## ***Rezoning Petition Review***

**Date of Review:** February 22, 2021 ***(Revised March 22, 2021)***

**Rezoning Petition #:** 21-026

**Location of Property:** Approximately 20.55 acres bound by the east side of Old Statesville Rd, the south side of Eastfield Rd.

CITY OF CHARLOTTE, MECKLENBURG COUNTY, NORTH CAROLINA  
FOR  
CIVIL CONSTRUCTION DOCUMENTS  
HENDRICK NORTH LAKE  
REZONING SITE PLAN

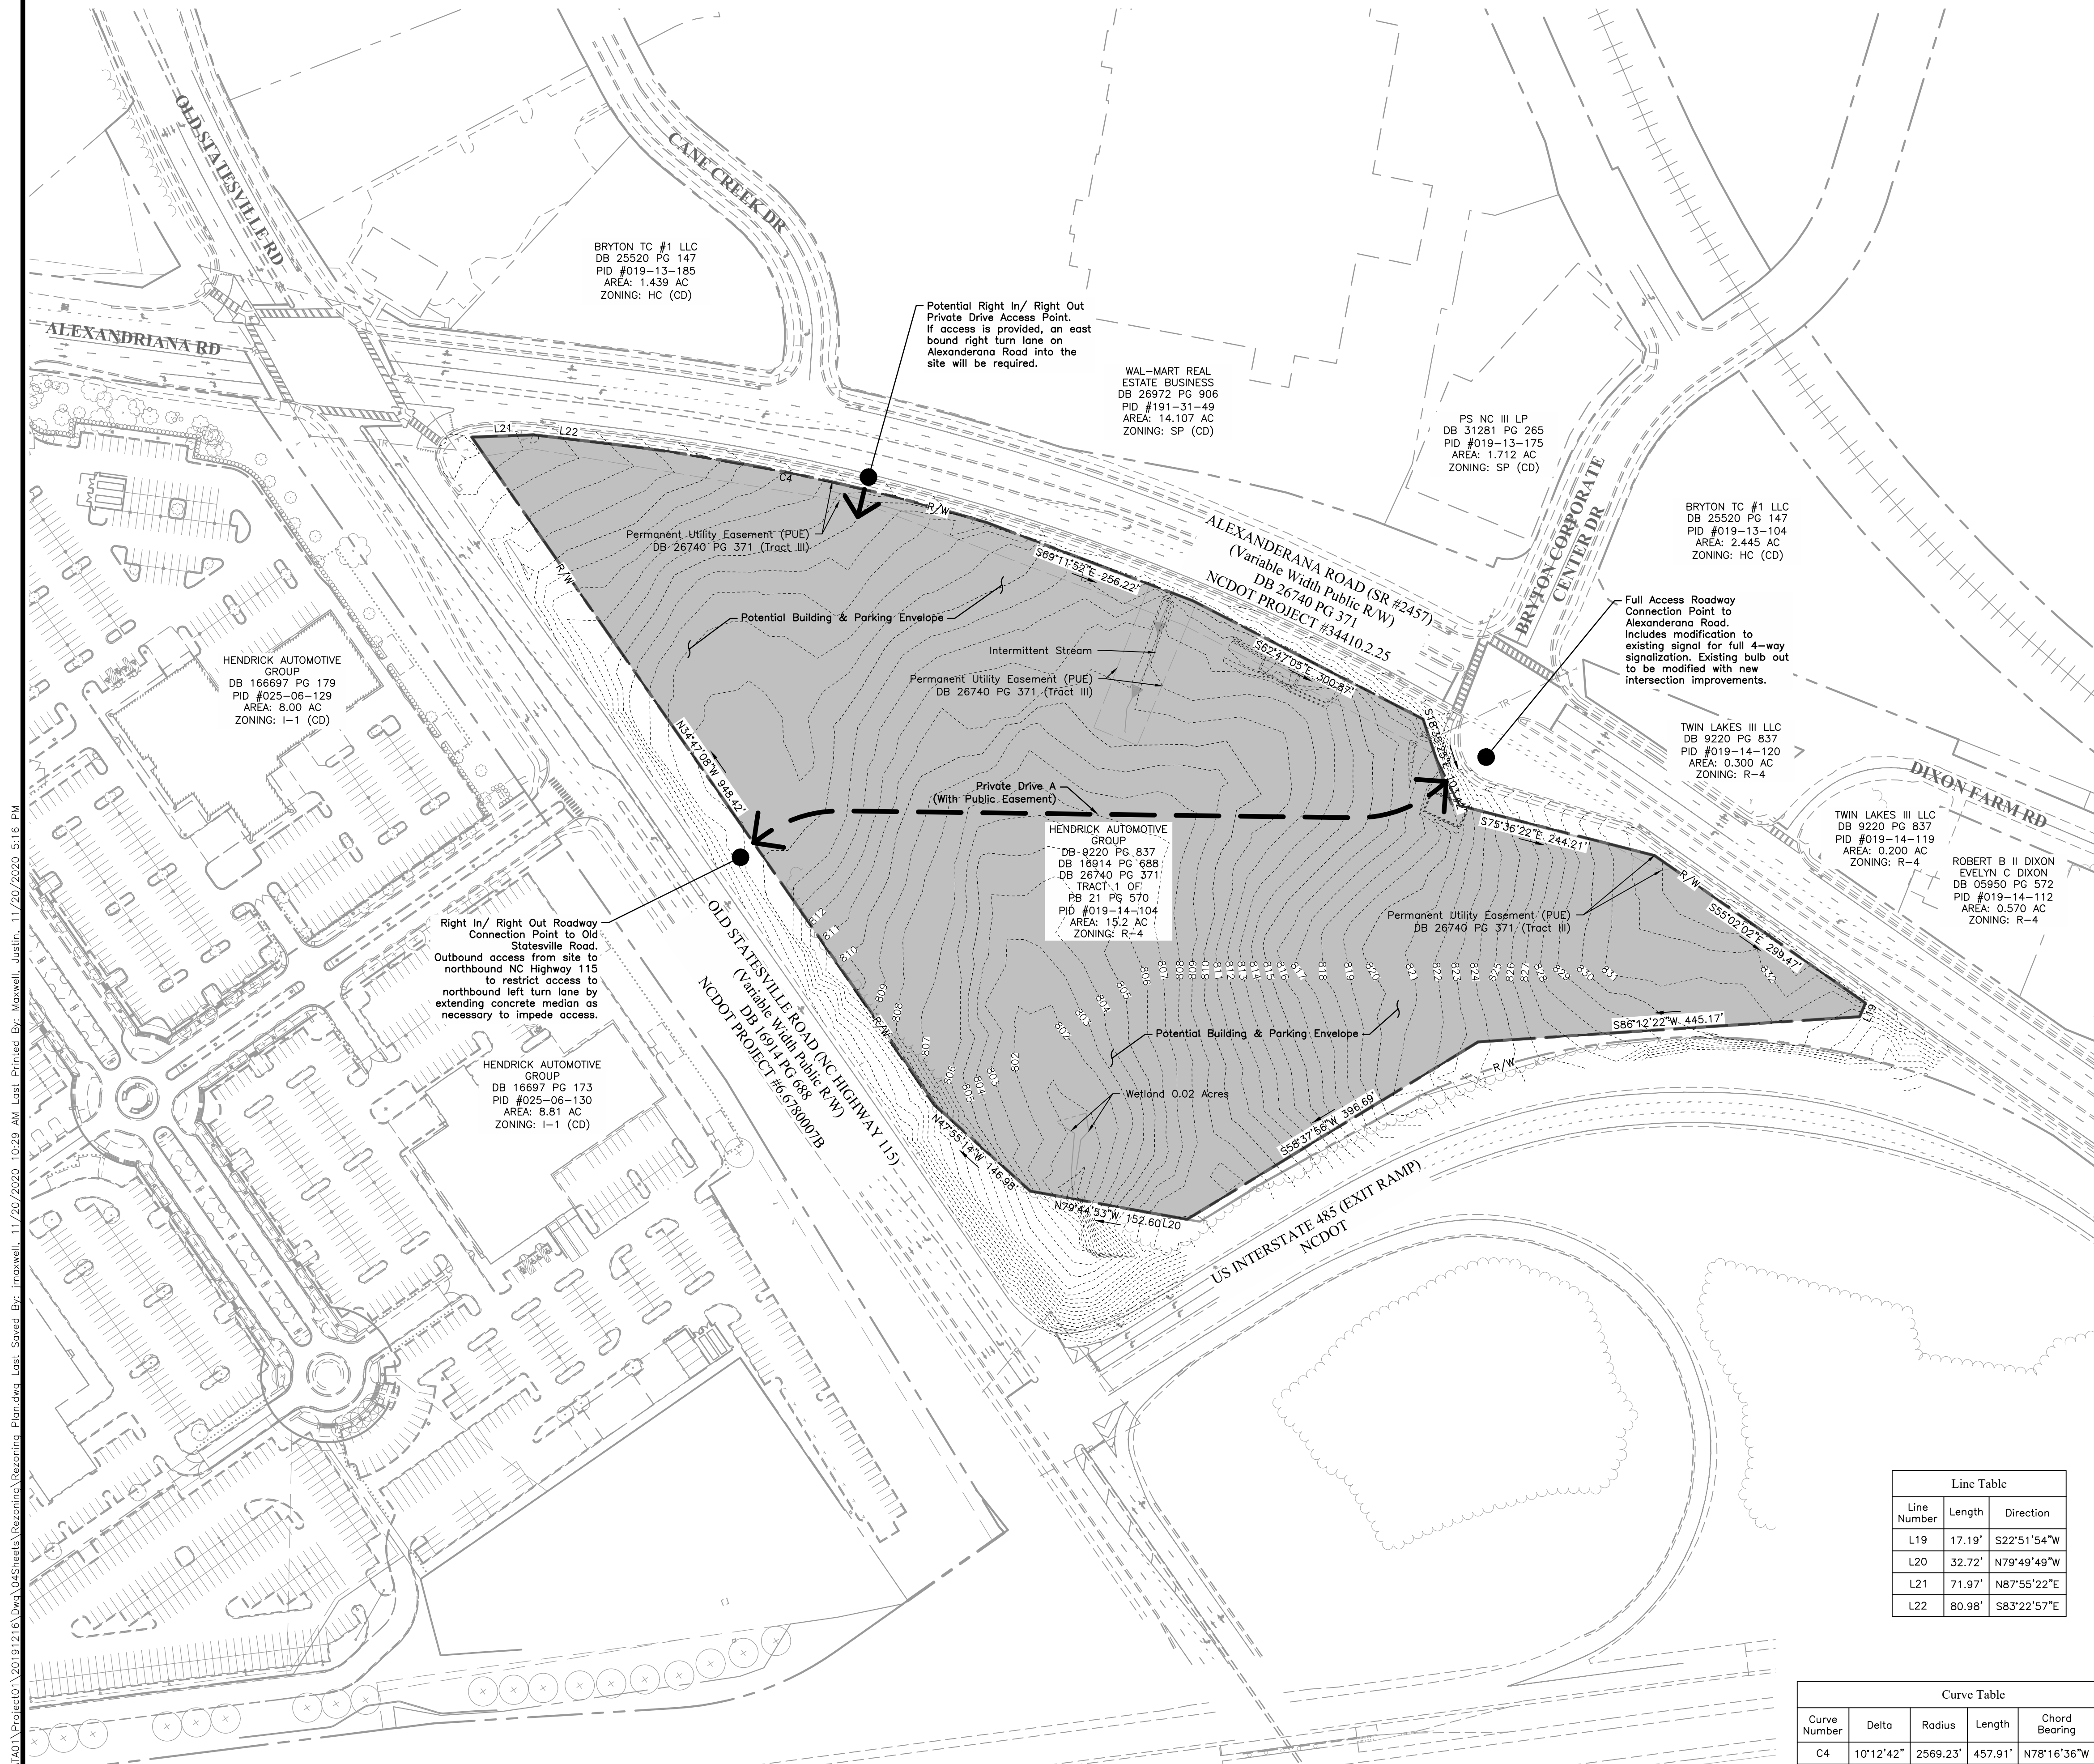
**Recommendations Concerning Storm Water:** The rezoning plan sheet indicates an intermittent stream on site. Please note perennial and intermittent streams require PCSO Buffers. Please include the following note under Environmental Features: *“Development within any SWIM/PCSO Buffer shall be coordinated with and subject to approval by Charlotte-Mecklenburg Storm Water Services and mitigated if required by City ordinance. Petitioner acknowledges intermittent/perennial stream delineation reports are subject to review and approval upon submission of development plans for permitting and are not approved with rezoning decisions.”*

***Due to revisions (3/22/21):*** No additional recommendations are needed at this time.
